**United Utilities Water Limited
Developer Services & Planning**
Warrington North WWTW
Gatewarth Industrial Estate
Barnard Street off Old Liverpool Road
Sankey Bridges
Warrington
WA5 1DS

Your ref: 3/2018/0511
Our ref: DC/18/2656
Date: 02-JUL-18

Location: Land adjacent to 17 Brookes Lane Whalley BB7 9RG
Proposal: Erection of three dwellings (revised proposal following planning permissions 3/2016/0771 and 3/2015/

APPENDIX 7 – Proposed Drainage Layout

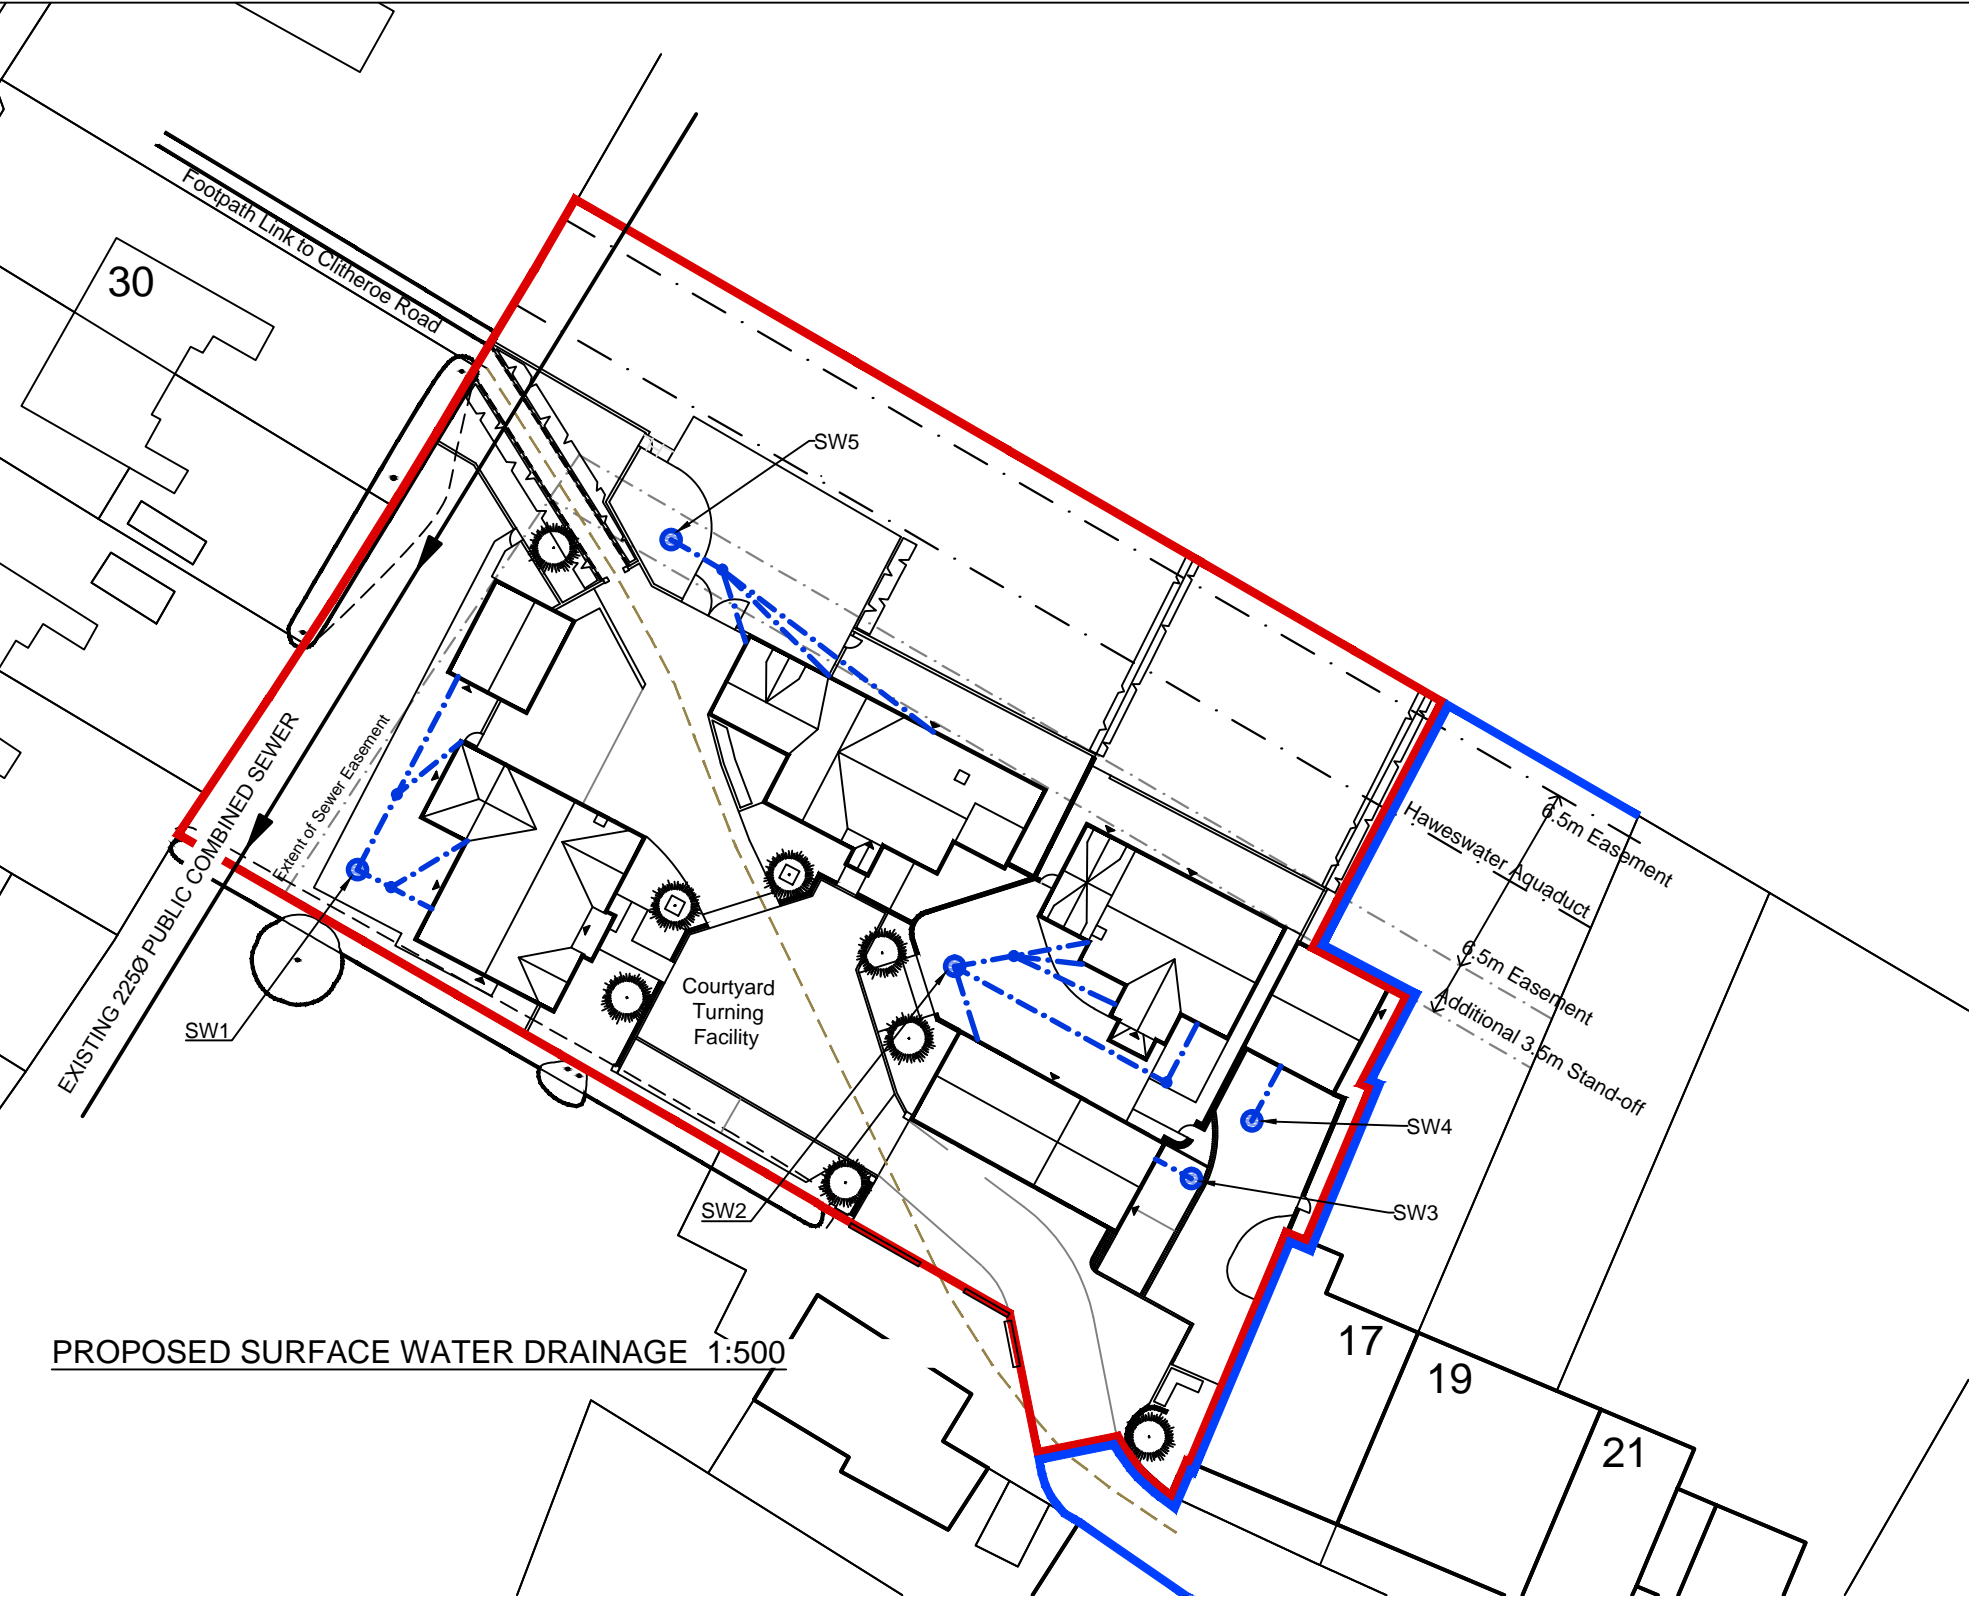
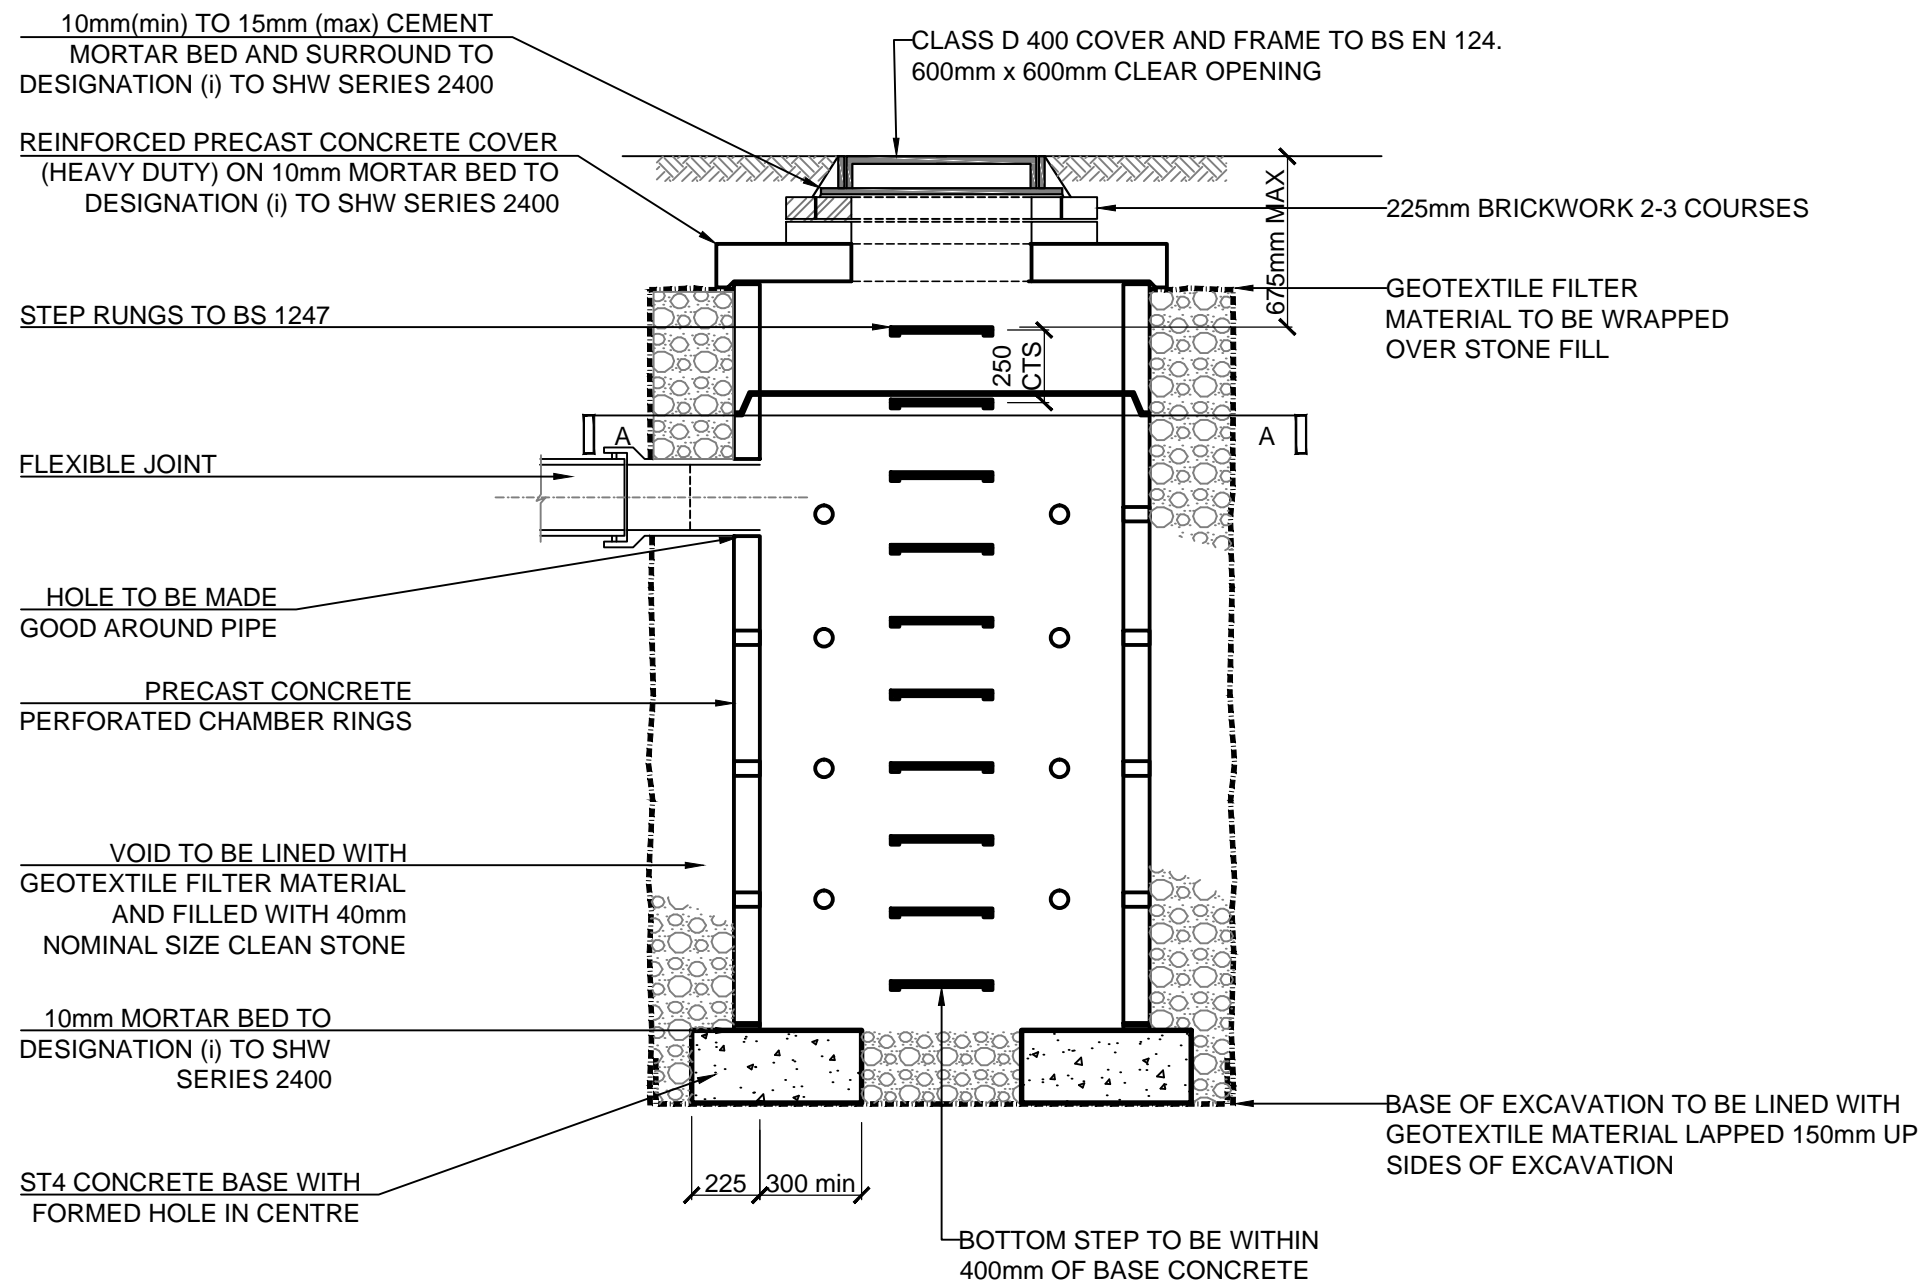
United Utilities can confirm that the drainage strategy is in line with United Utilities requirements.

In accordance with the National Planning Policy Framework (NPPF) and the National Planning Practice Guidance (NPPG), the site should be drained on a separate system with foul water draining to the public sewer and surface water draining in the most sustainable way. The NPPG clearly outlines the hierarchy to be investigated by the developer when considering a surface water drainage strategy. We would ask the applicant to consider the following drainage options in the following order of priority:

Foul and surface water shall be drained on separate systems. Surface water shall be drained in accordance with the hierarchy of drainage options in national planning practice guidance. In the event of surface water discharging to public sewer, the rate of discharge shall be restricted to the lowest possible rate which shall be agreed with the statutory undertaker prior to connection to the public sewer.
